Our Ref: FP/242/17/HH
Your Ref:

Town & Country Planning Act 1990 (as amended)
Town & country Planning (Development Management Procedure) (England) Order 2015
Application for Planning Permission for Works or Extension to a Dwelling

Development Retention of rear extension
Location 29 Davenport Road Felpham

Block Plan Amend

BLOCK PLAN
SCALE 1:500

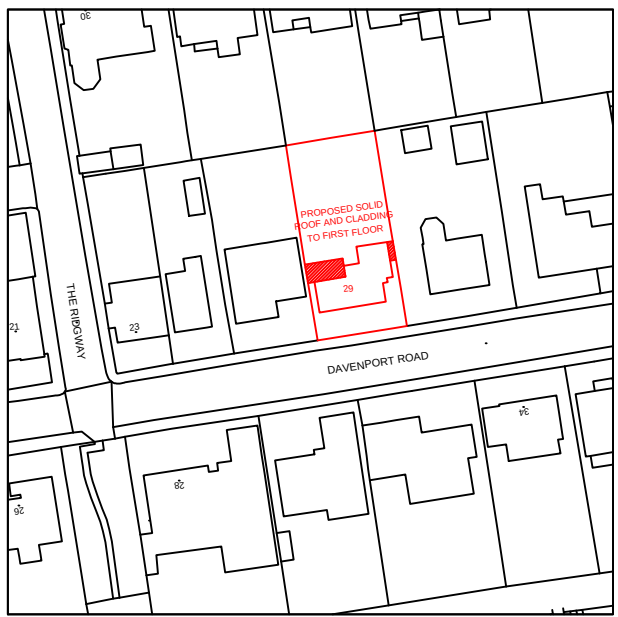
Please submit 1 electronic or 3 paper copies of a block/site plan at a scale of 1:500 or 1:200. Further details of what must be included on the plan can be found in the National Validation Requirements. Please hatch/highlight all proposed works and provide measurements from the proposal to the site boundaries.
